7 May 2020

**SECTION 4.55(1A) MODIFICATION APPLICATION
BAYS 1-4A, LOCOMOTIVE WORKSHOPS, SOUTH EVELEIGH (SSD 8517)**

The modification relates to amendments to the internal design and layout of Bays 3-4a that respond to the requirements of future tenants within the Locomotive Workshop. The modification also includes amendments to the Condition B37 and a new Condition B37A, which together relate to the process and timing for the submission of detailed landscape and public domain plans.

Scale 1 : 250 @A1 (Half Scale @ A3)			Rev Date 10/12/19			North			Project No. 16-002			Drawing No. SA-AR-DWG-BB-B4-0330			Rev AA

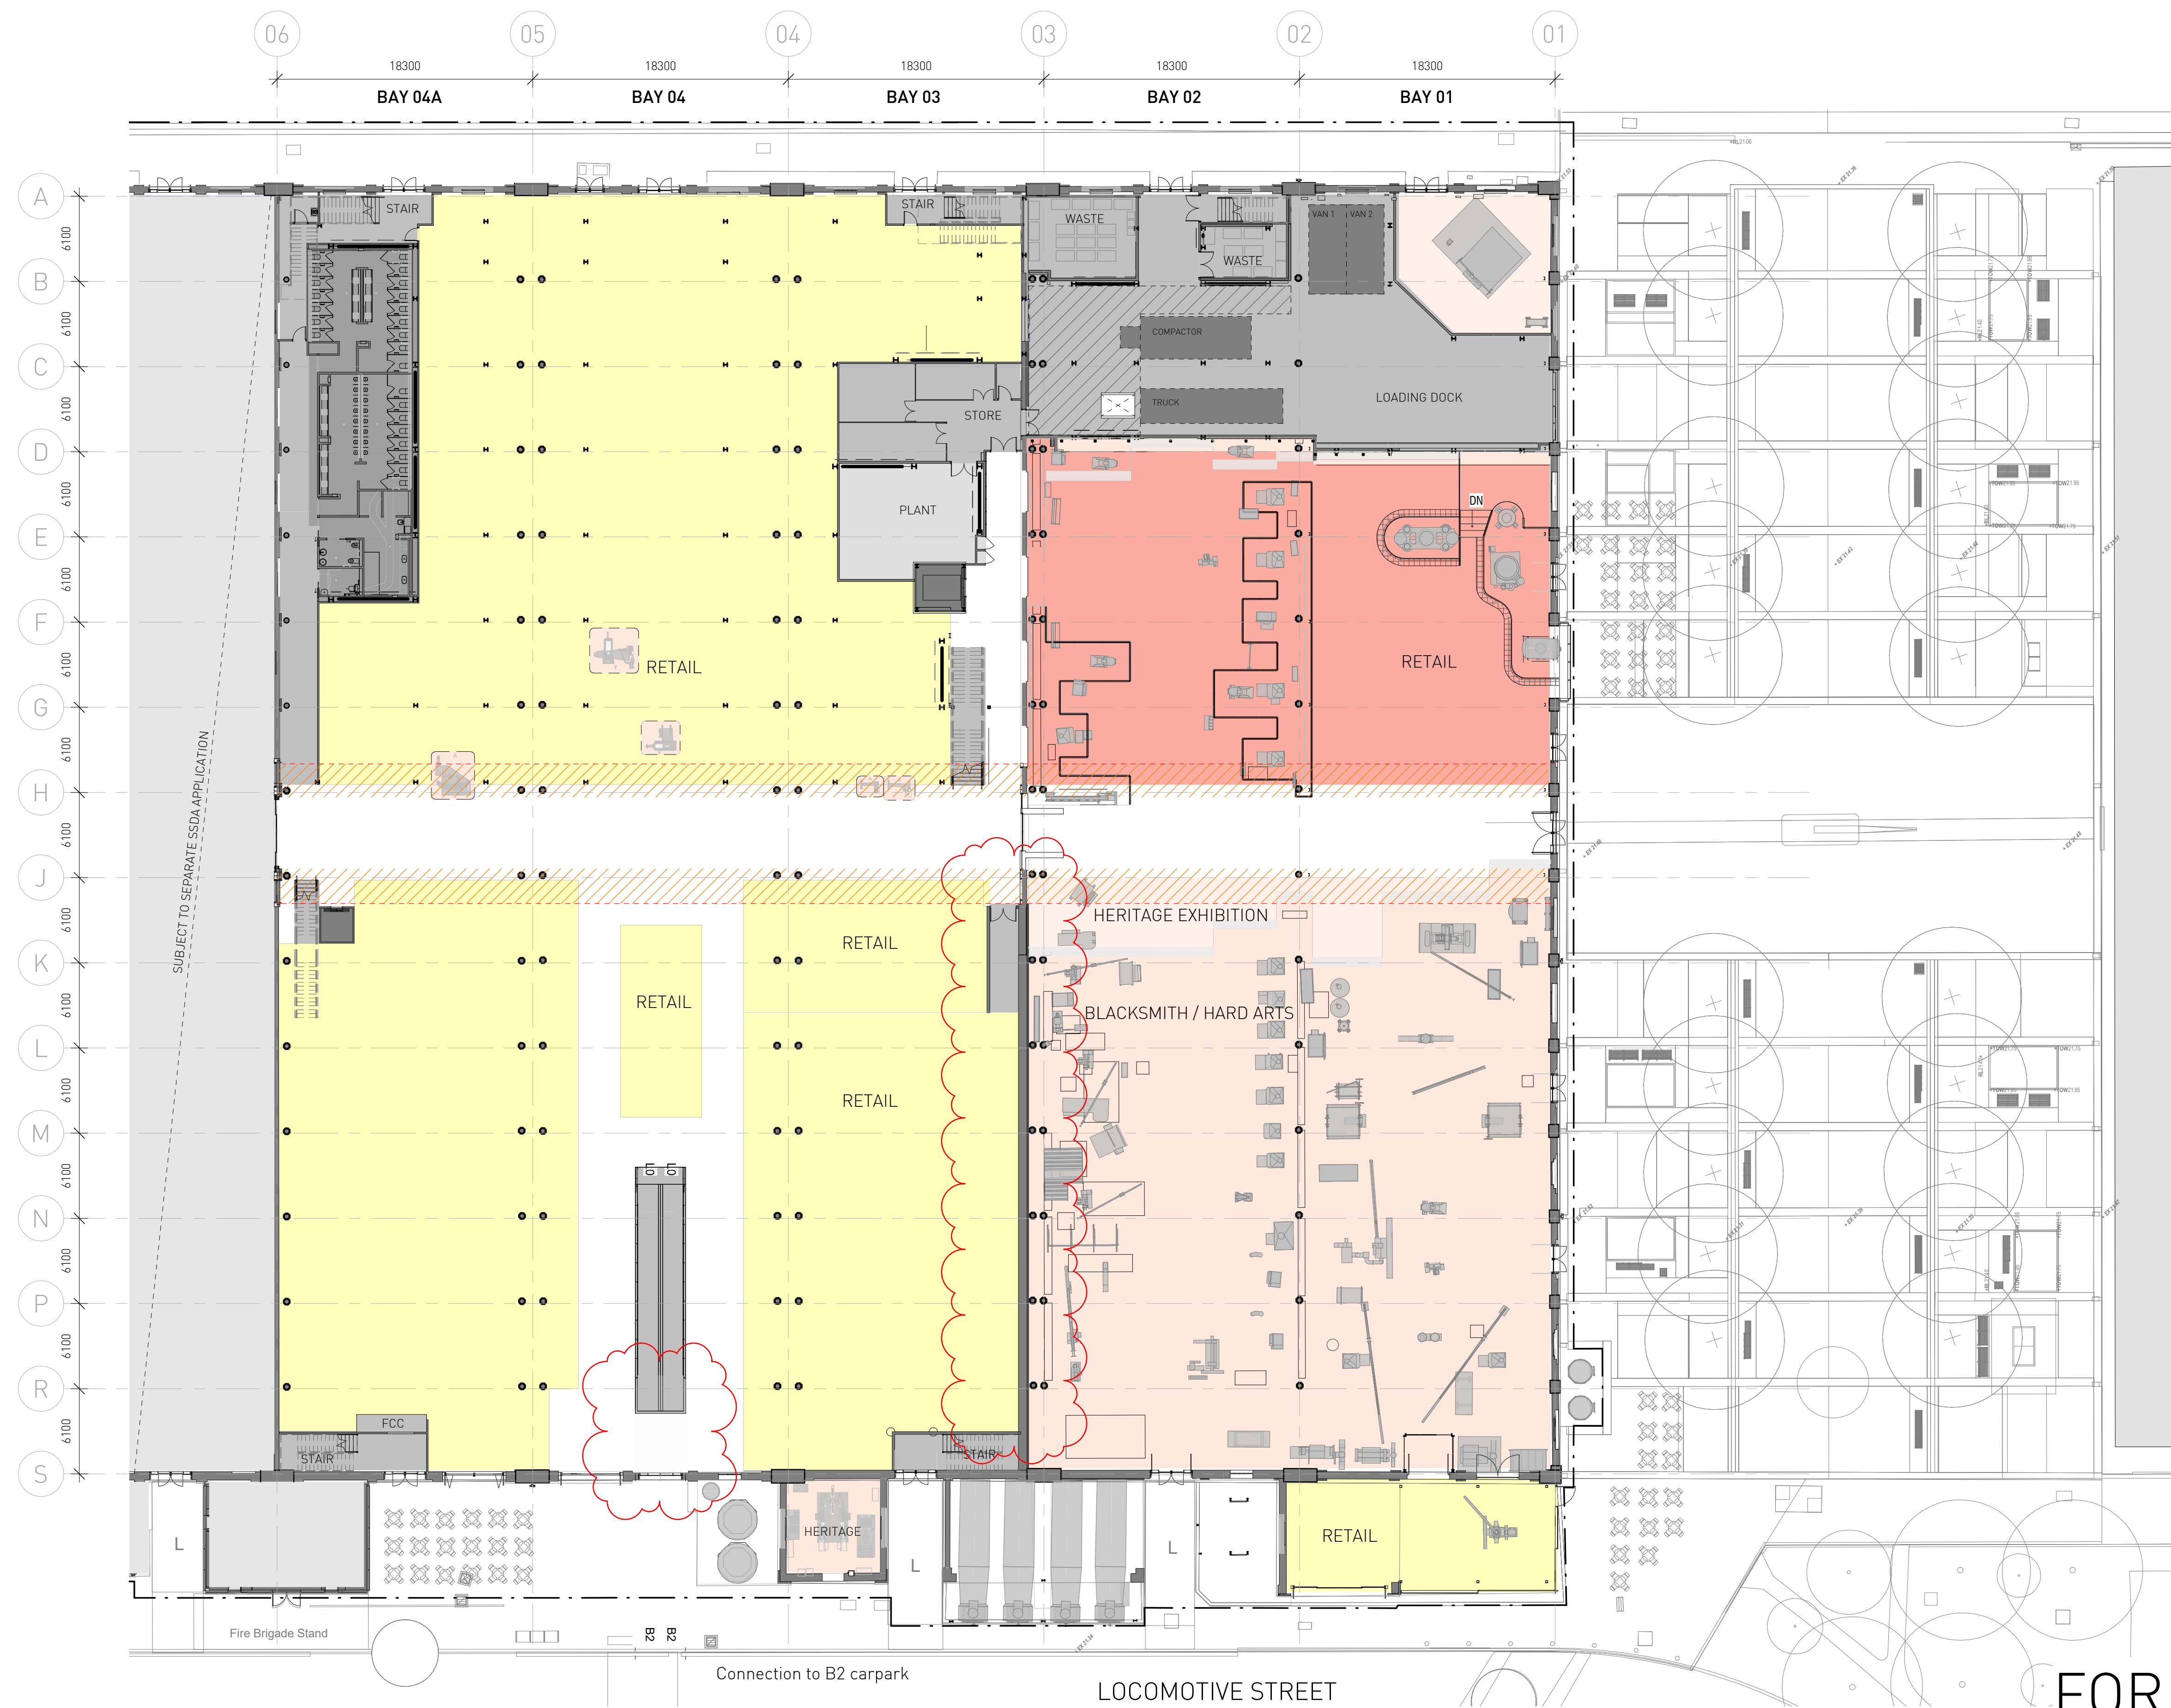
- Conversion of back of house corridor on the Ground Floor of Bay 3 South to retail uses;
- Deletion of void space over the travelator tunnel on the Ground Floor of Bay 4 South;
- Narrowing of the bridge over Bay 4 South on Level 1;
- Removal of the viewing platform in Bay 3 on Level 1, along the central spine of the Locomotive Workshop.
- Reduction in the extent of the mezzanines over Bay 3 and Bay 4.
